Greenwich Hospital Redevelopment– Detailed Design (SSD-13619238)

Submission

REVISION: P10
DATE: 01/18/21
DRAWING TITLE:
STAGE 3.2 PLAN - CONSTRUCTION

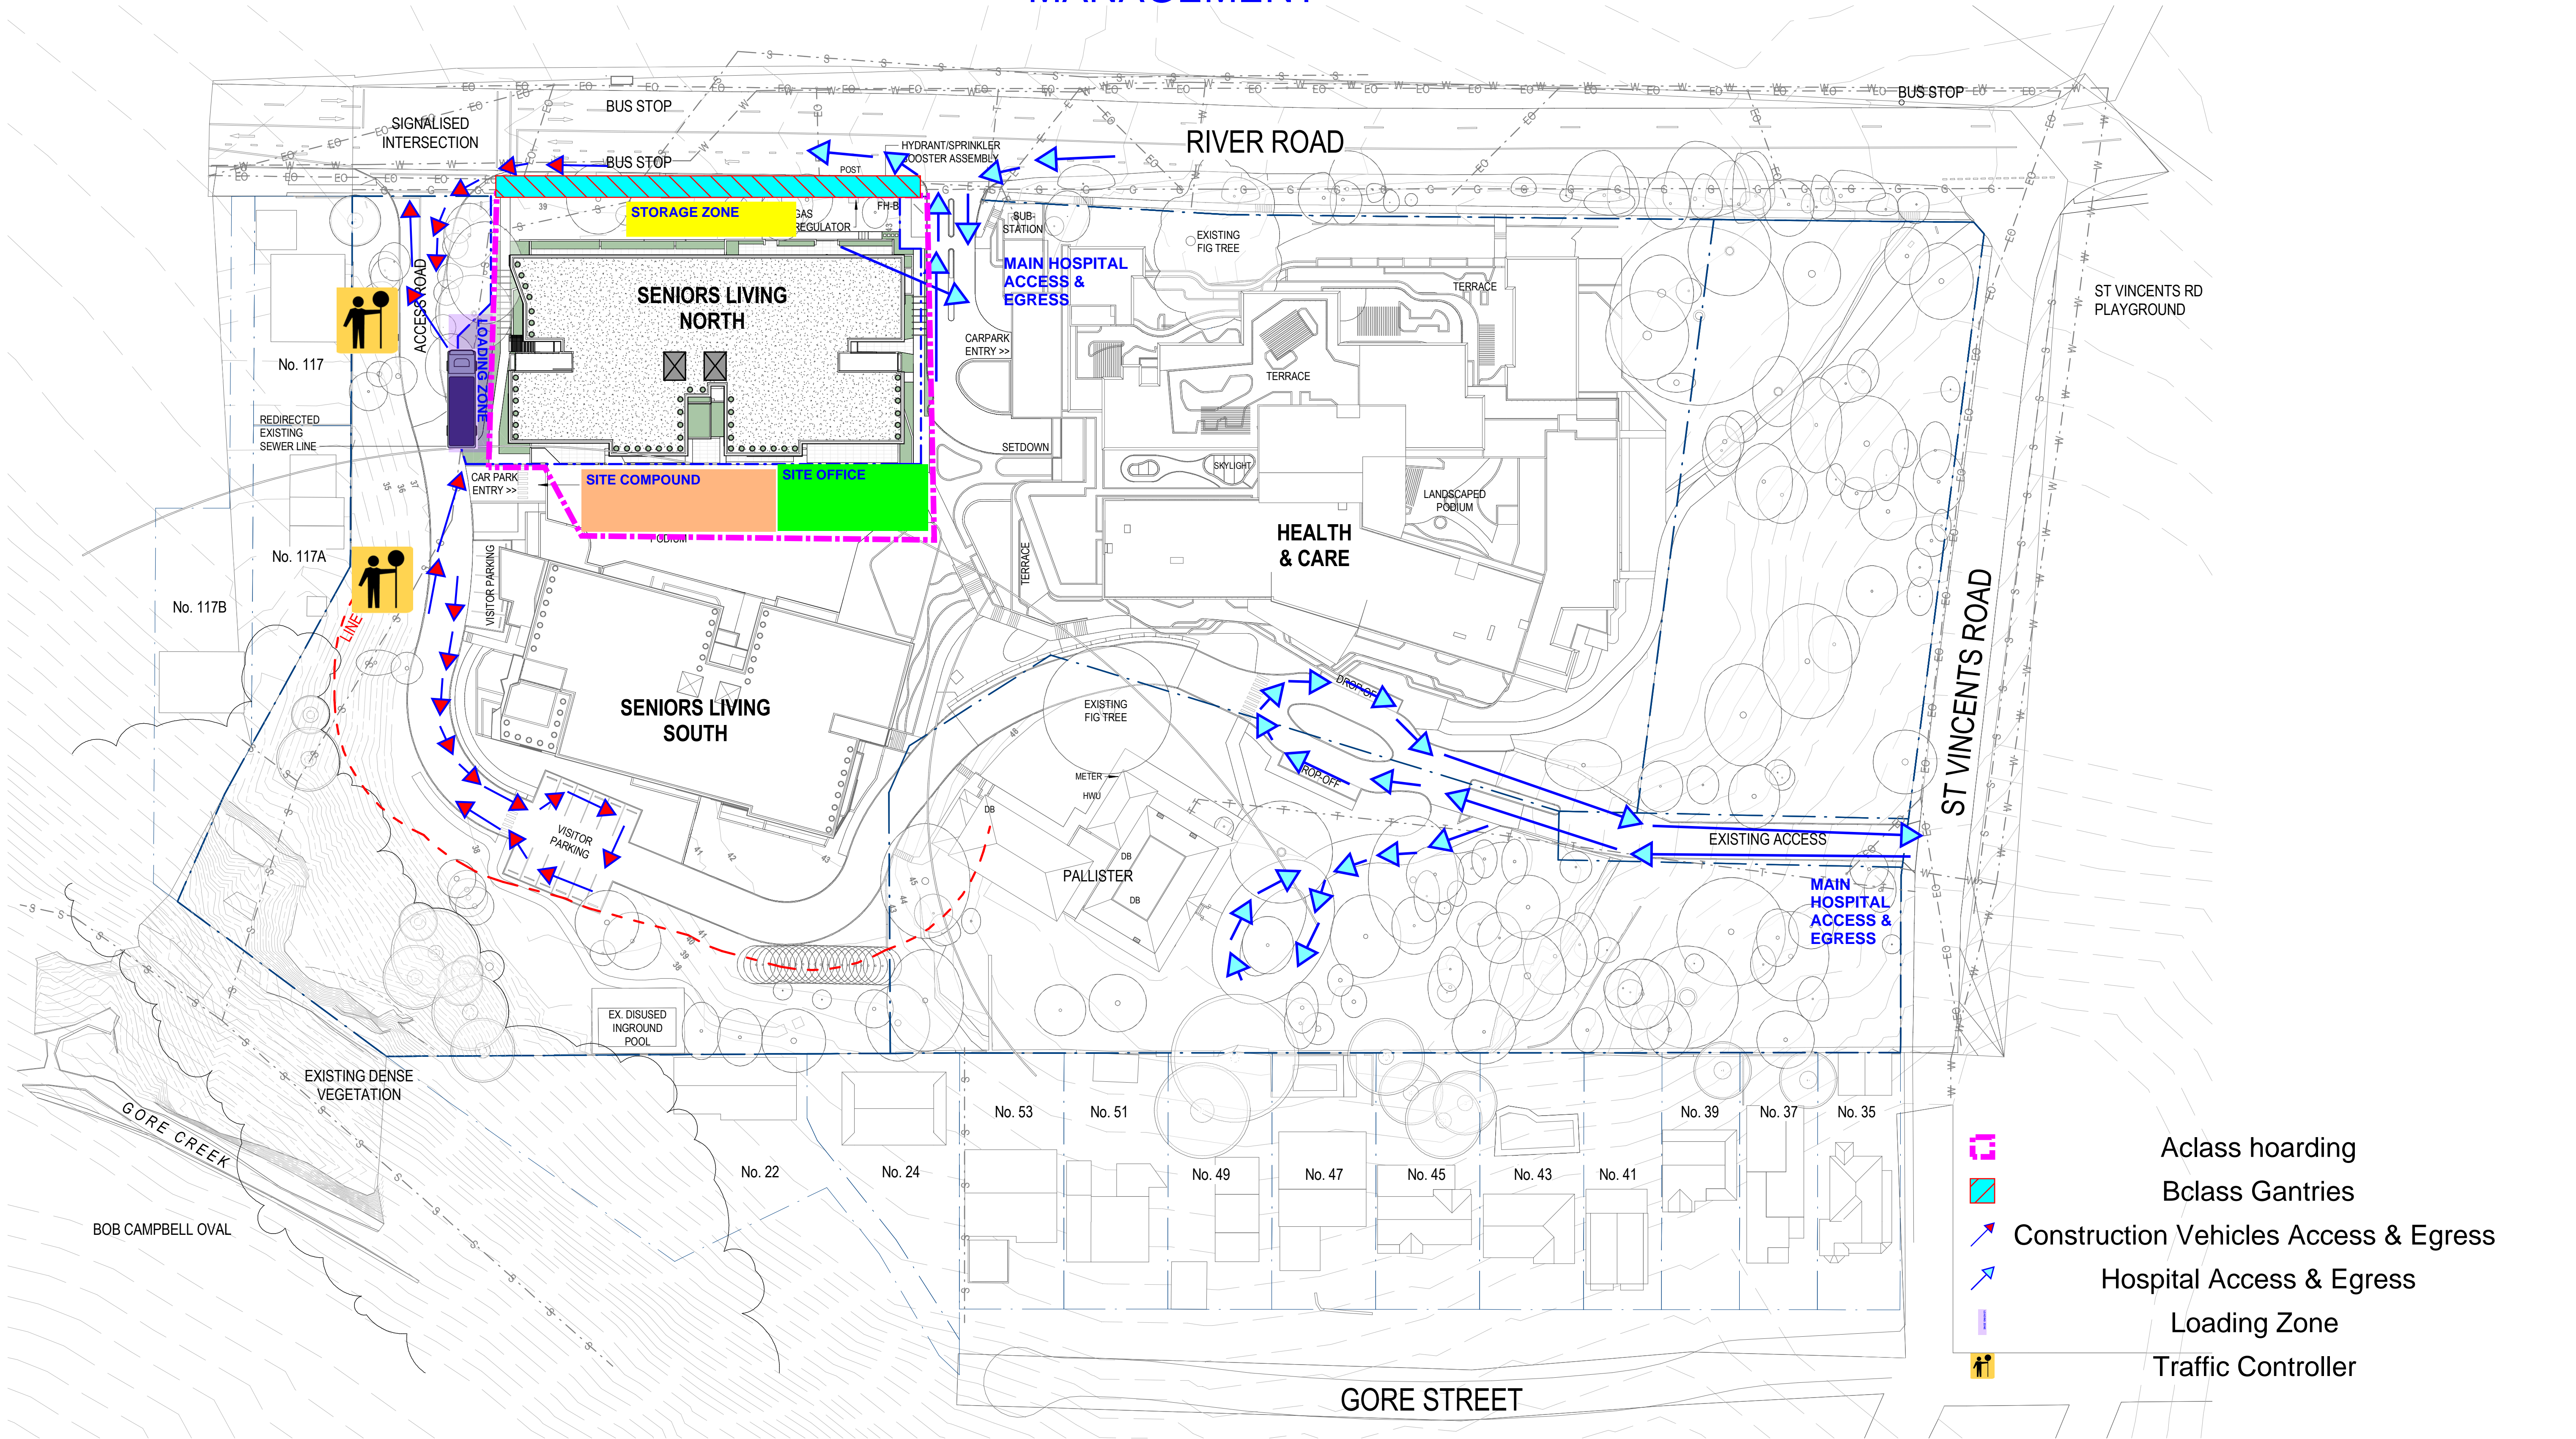
- The *Construction Management Plan* mentions an ESCP on p.27 and at 4.4.6.9, p31 but these only pertain to drain protection and truck washing.
- The *Stormwater Management Plan* shows details for Erosion and Sediment Control for Stage 3 in a plan on p.18. this includes a perimeter sediment control fence for the entire Stage 3 works, accompanied by a drawing with some details of this fence. While specifications indicate a stronger fence than the sediment fencing in Appendix Photo 1, as a single fence apparently less than a metre high, it would not be enough to hold the sediment flows we have seen from the site in Photos 1 and 2. ***The fencing should be higher and the controls strengthened to a double fence across the bushland slope portion of the perimeter.***

This is particularly important, given the *Construction Management Plan* shows the area immediately adjacent inside the works area of Stage 3 to be a truck marshalling area and a lot of truck movements will be occurring here through the project.
